**WELWYN HATFIELD BOROUGH COUNCIL  
EXECUTIVE DIRECTOR - PLANNING, PUBLIC PROTECTION AND GOVERNANCE**

**Application No:** 6/2020/3010/LAWE  
**Location:** 51 Kentish Lane Hatfield AL9 6NG  
**Proposal:** Certificate of lawfulness for the existing outbuilding  
**Officer:** Ms Lois-May Chapman

**Recommendation:** Refused

Drawing file: Document / Download

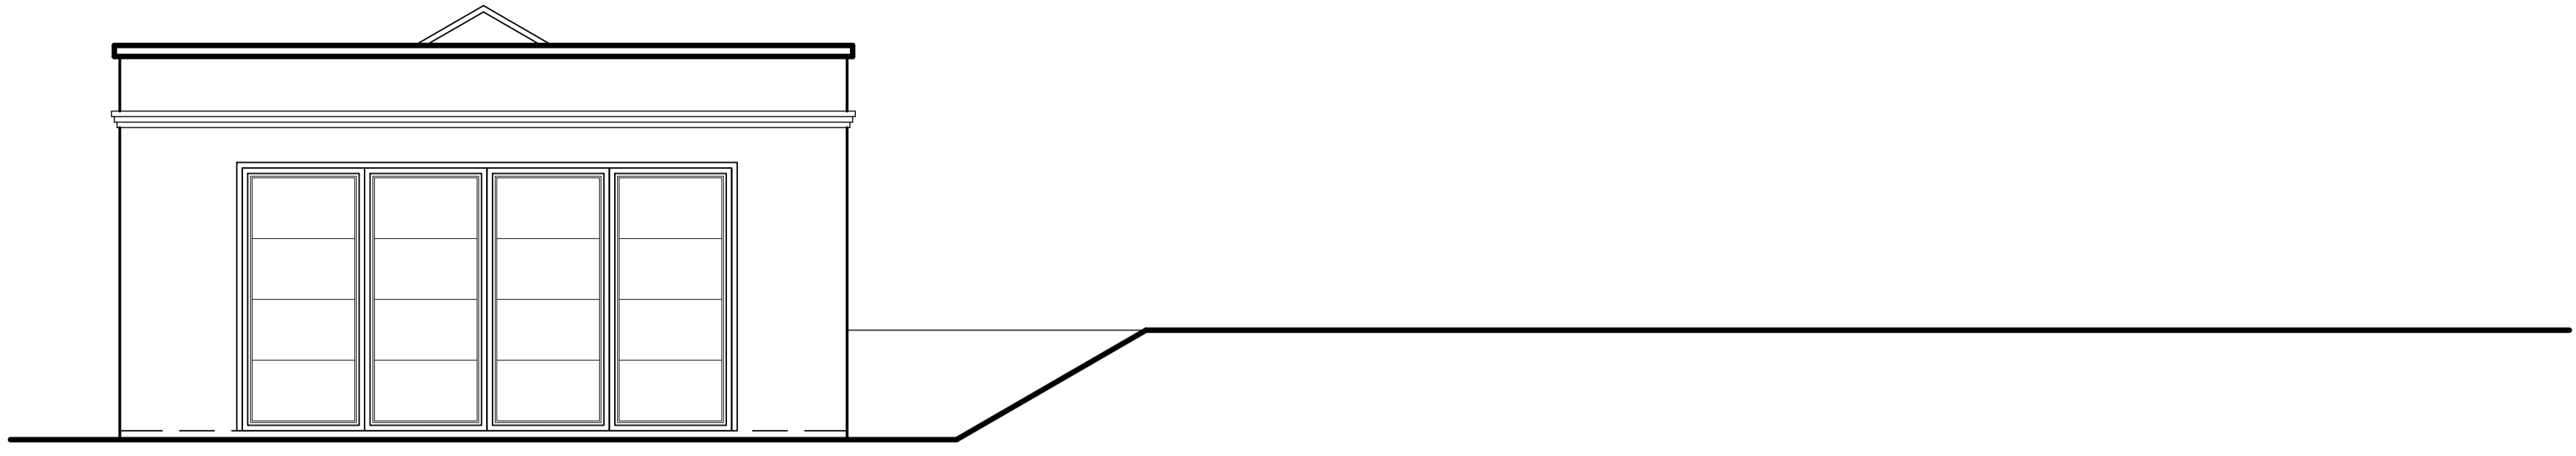
(d) the building would have more than a single storey;	<b>N</b>	N
(e) the height of the building, enclosure or container would exceed— (i) 4 metres in the case of a building with a dual-pitched roof, (ii) 2.5 metres in the case of a building, enclosure or container within 2 metres of the boundary of the curtilage of the dwellinghouse, or (iii) 3 metres in any other case;	<b>Y</b> -2.9m in height within 2m bounda ry	N

(f) the height of the eaves of the building would exceed 2.5 metres;	<b>Y</b> - 2.9m	N
(g) the building, enclosure, pool or container would be situated within the curtilage of a listed building;	<b>N</b>	N

(h) it would include the construction or provision of a verandah, balcony or raised platform;	<b>Y</b>	N
(i) it relates to a dwelling or a microwave antenna; or	<b>N</b>	N

The outbuilding includes the provision of a verandah which fails to comply with E.1 (h).

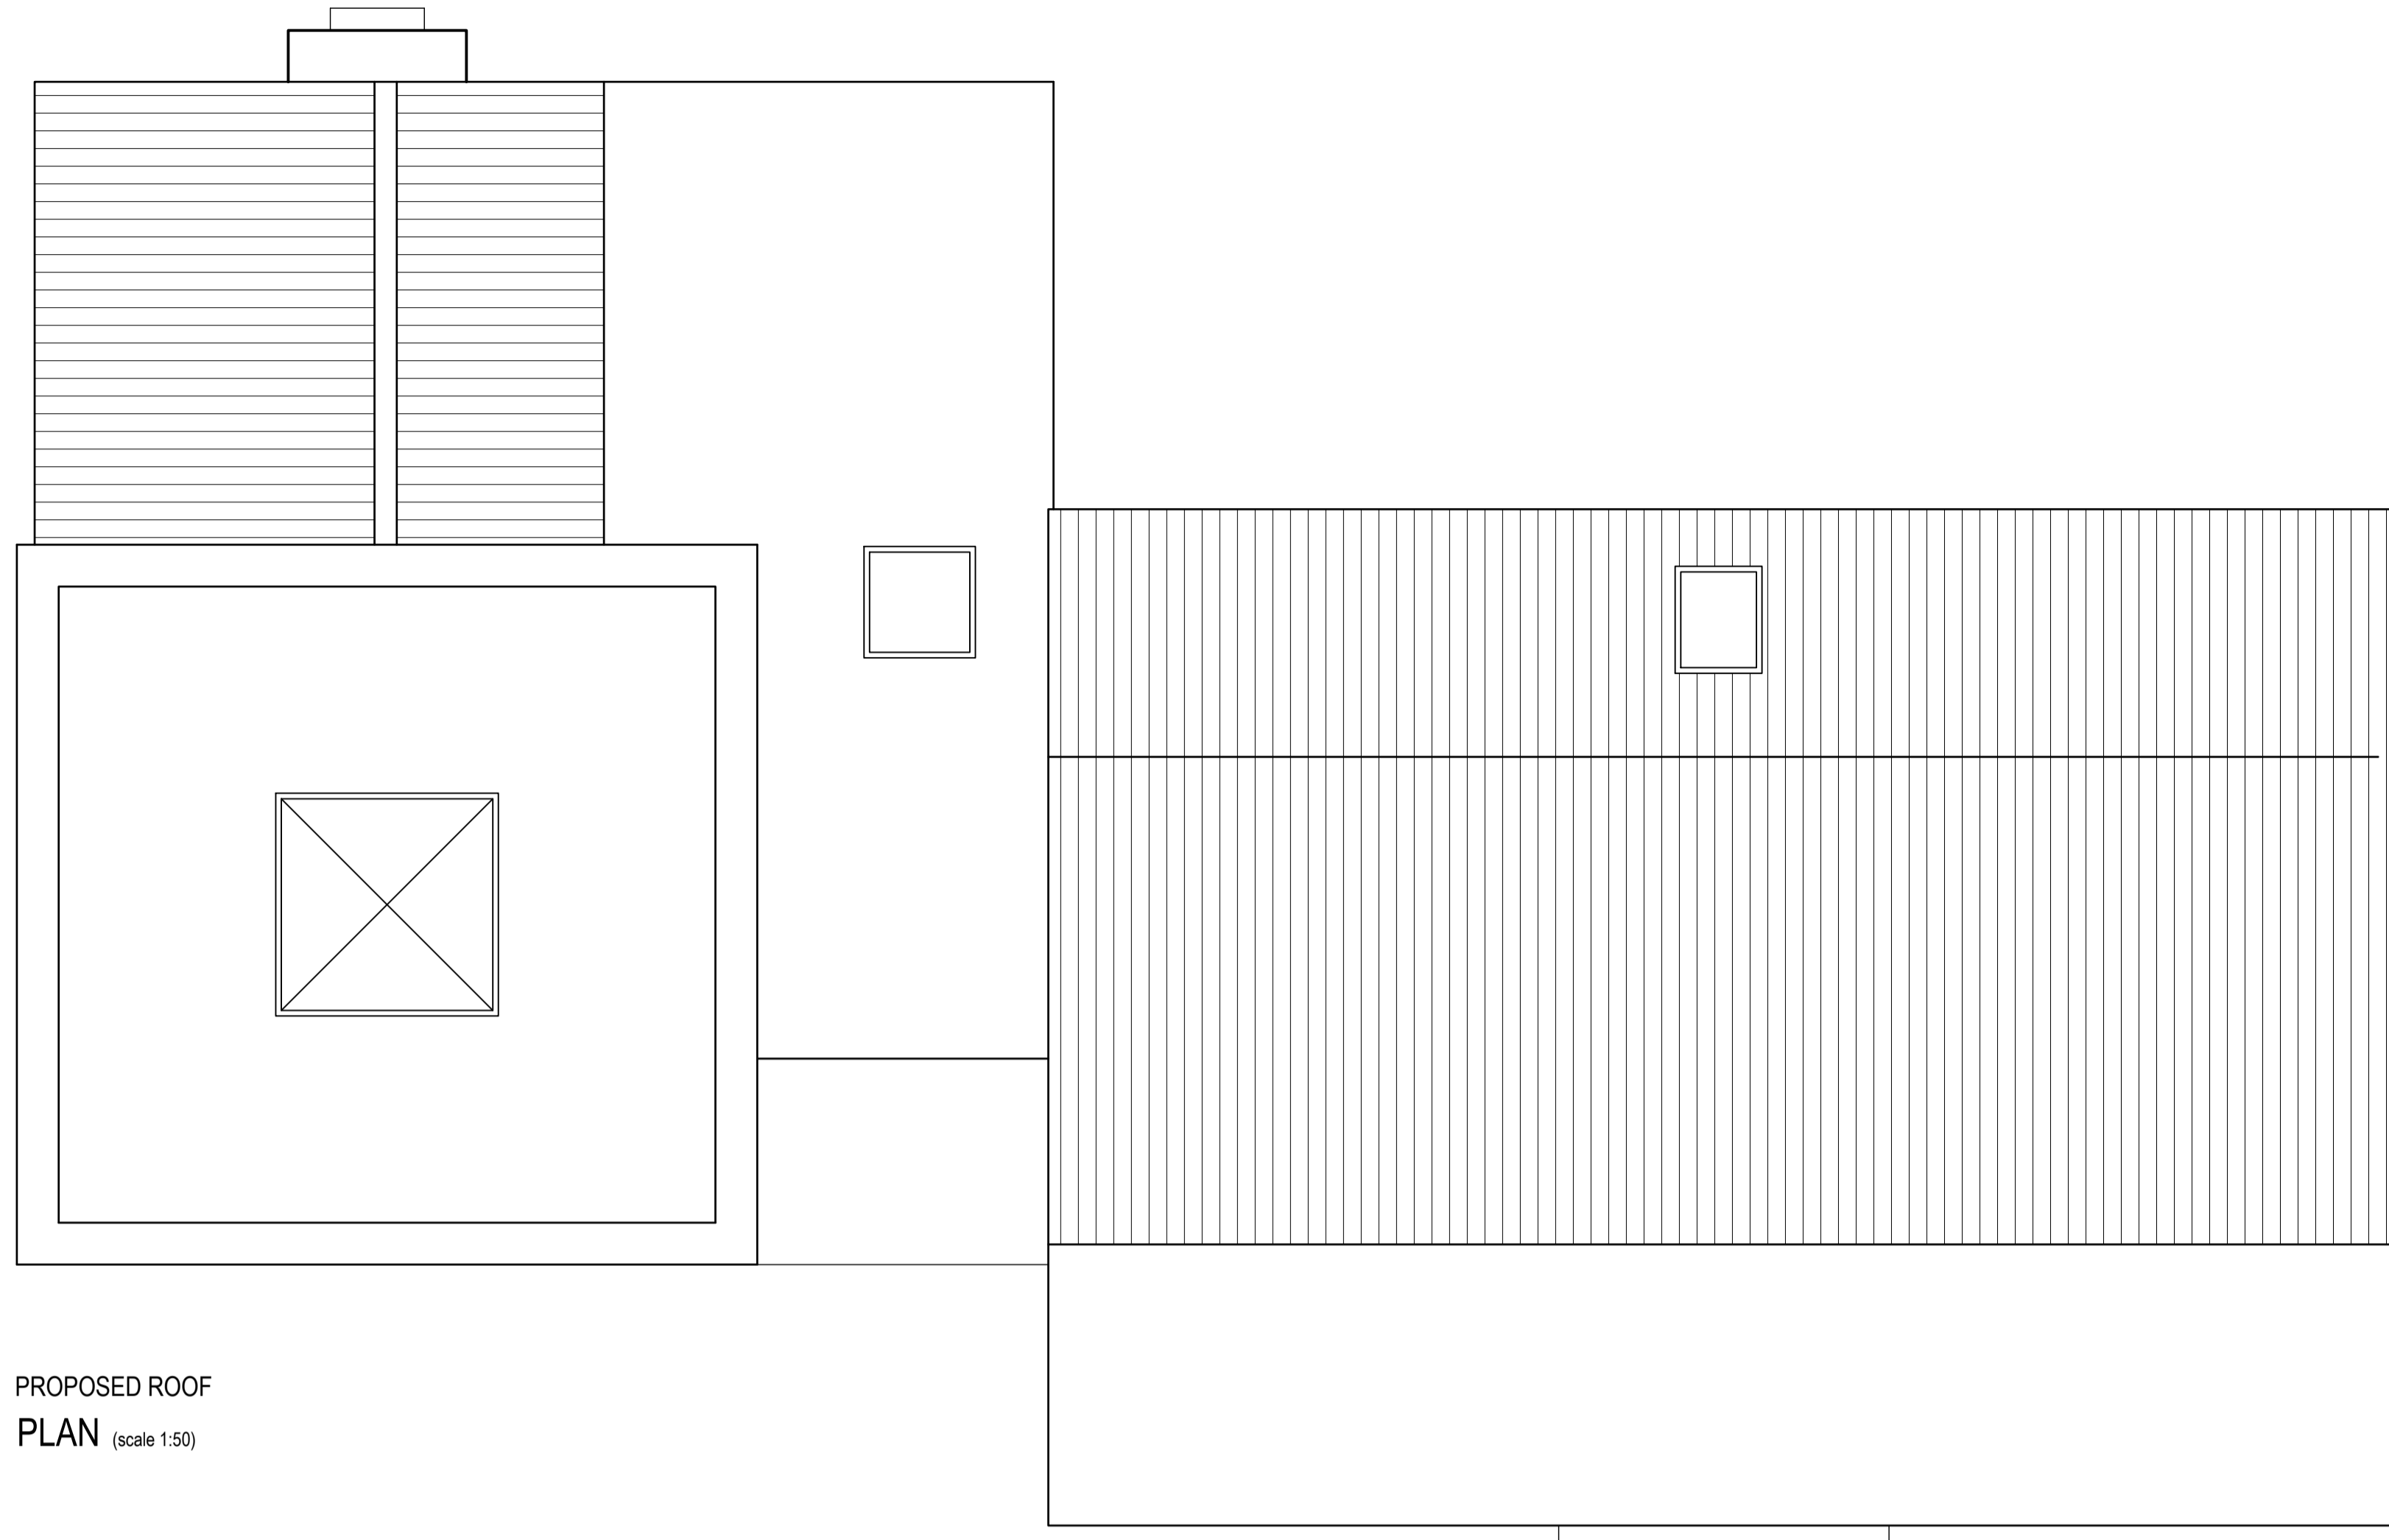
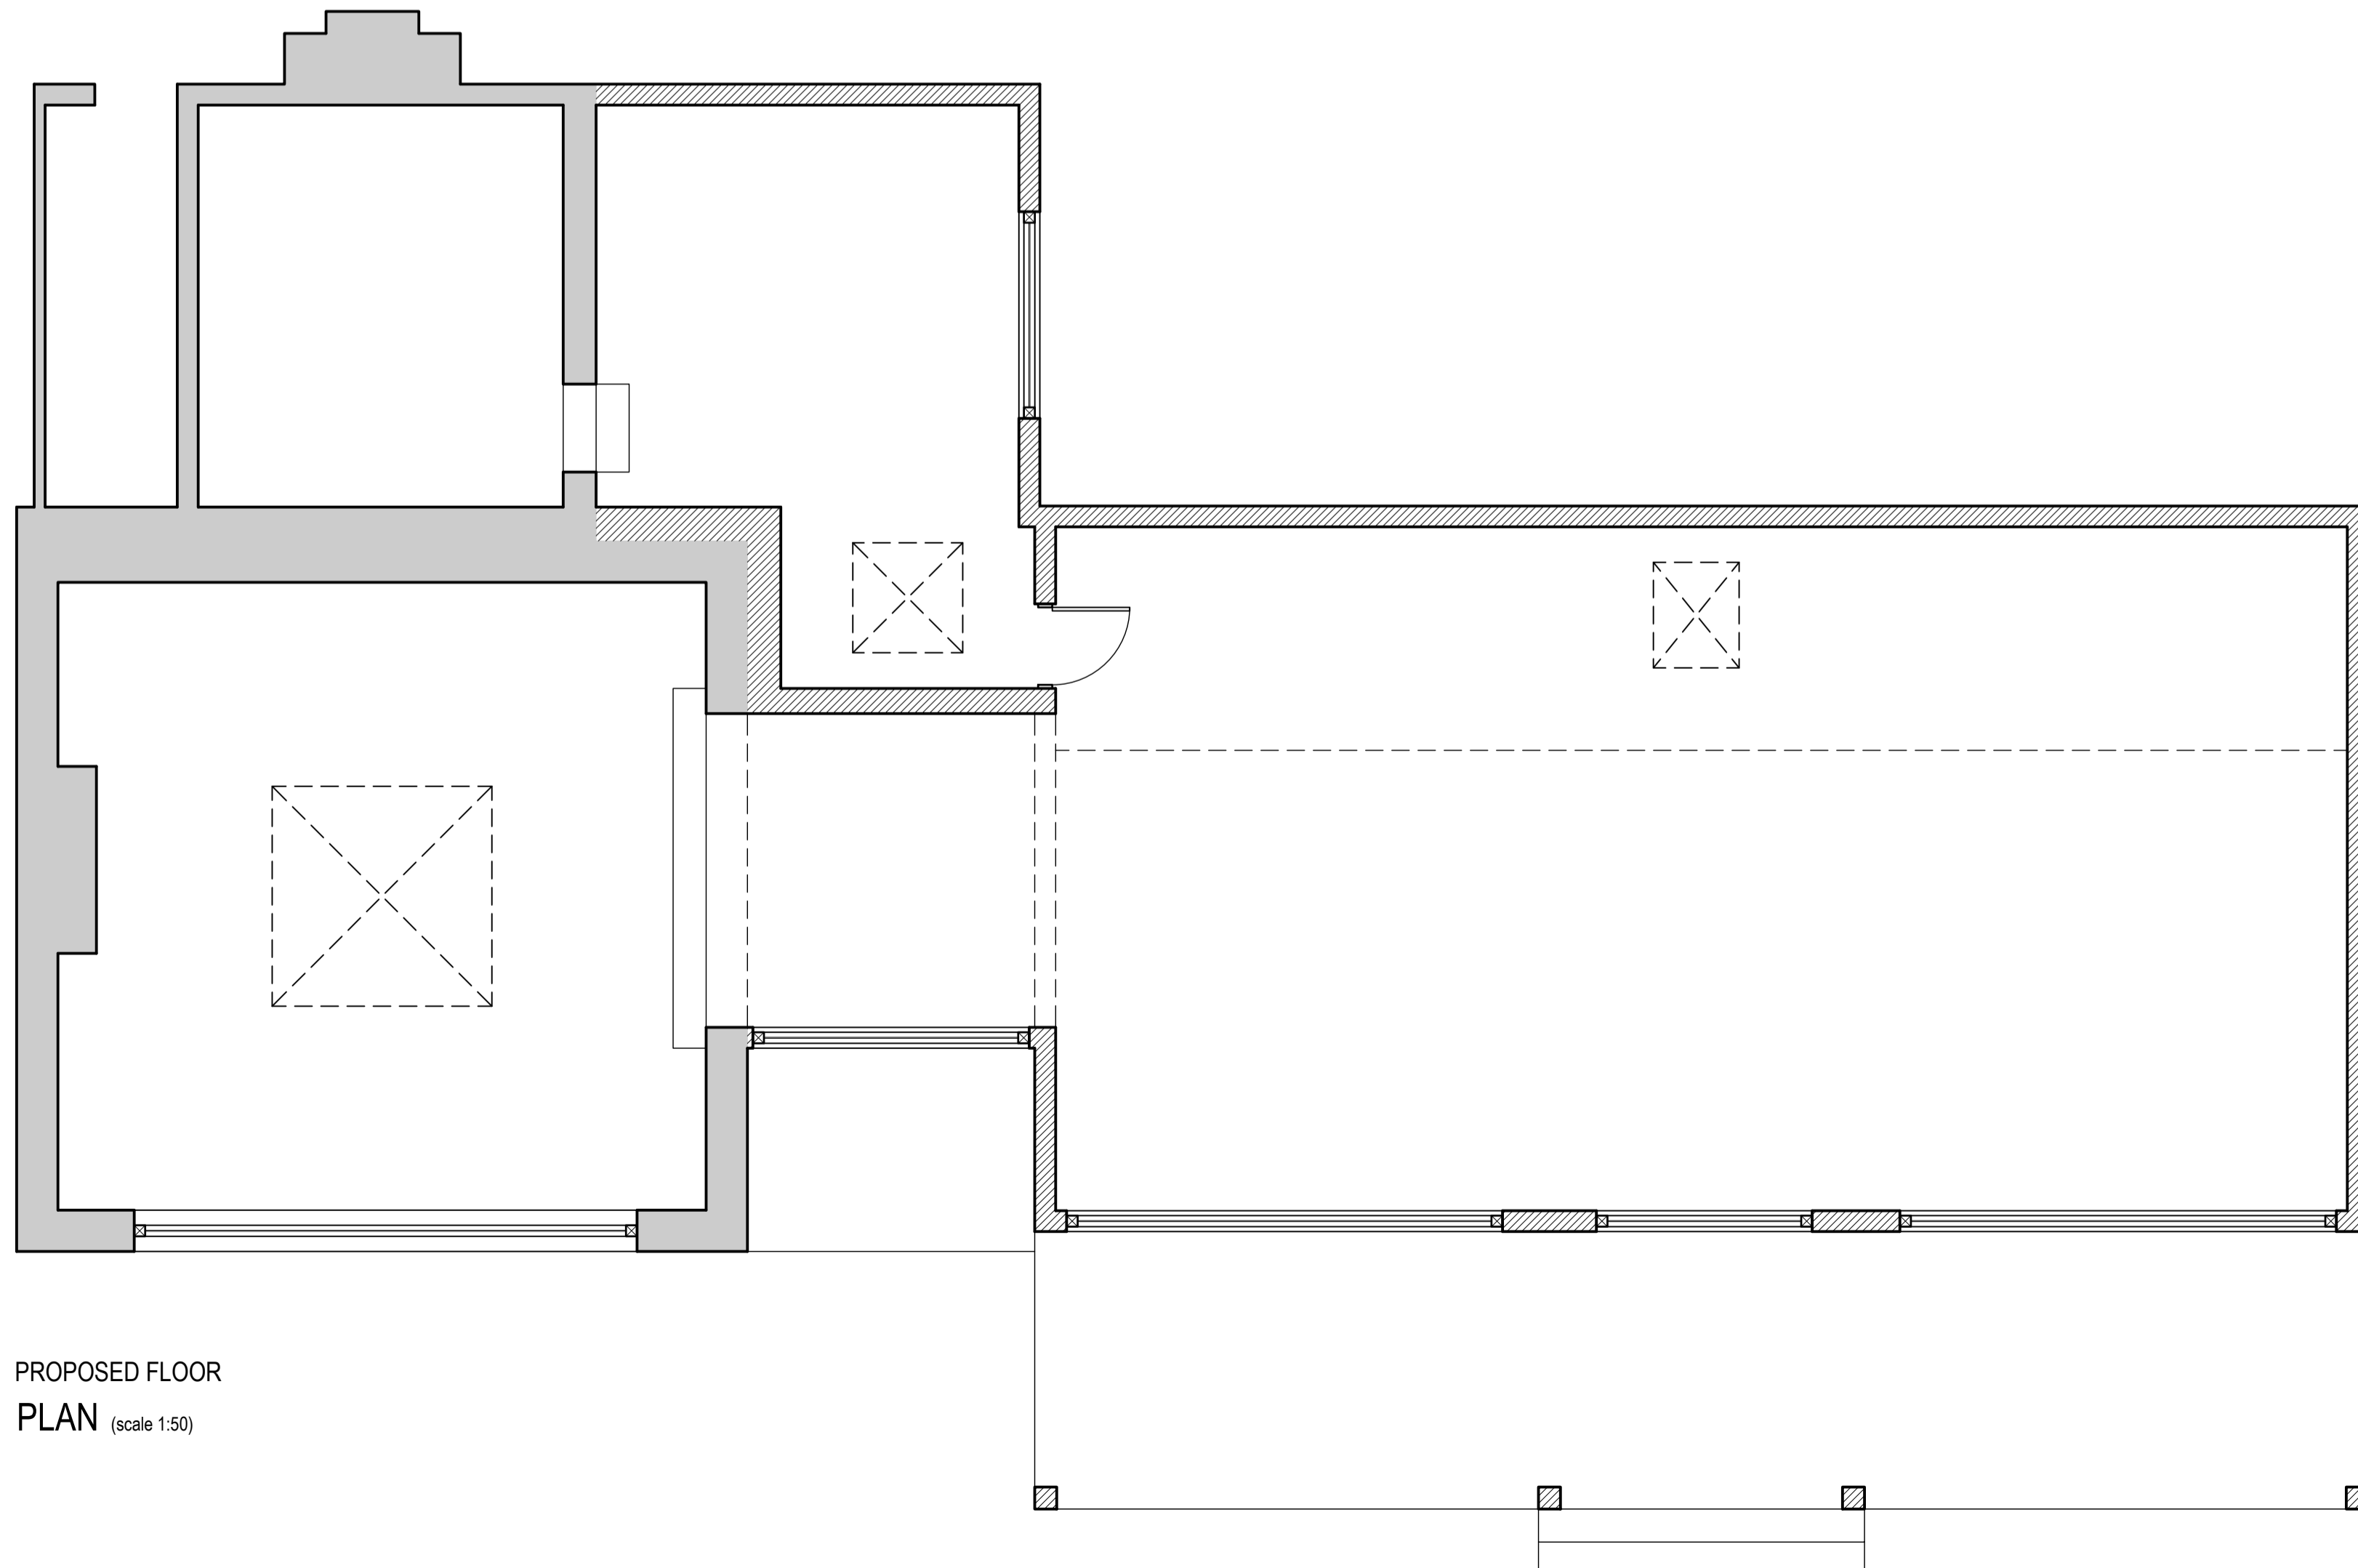
The cover letter indicates that the outbuilding has been used as an art gallery, however once extended, its footprint is a similar size to the dwelling house. The applicant has not provided further explanation as to why this significantly large outbuilding is reasonably required for the incidental enjoyment of the dwellinghouse. The submitted drawings do not identify the layout of the gallery nor any indication of what it may look like once paintings are installed. The overall scale of the development is considered to be excessive and exceeds what may be reasonably considered as incidental to the enjoyment of the dwellinghouse. Although the activities designated on the plans of the new building fall into categories that, individually, may be acceptable as incidental to the enjoyment of the dwelling house, taken together they occupy an unreasonable amount of space. Thus as a matter of fact and degree, the proposal does not come within the terms of Class E of Part 1 of GPDO.
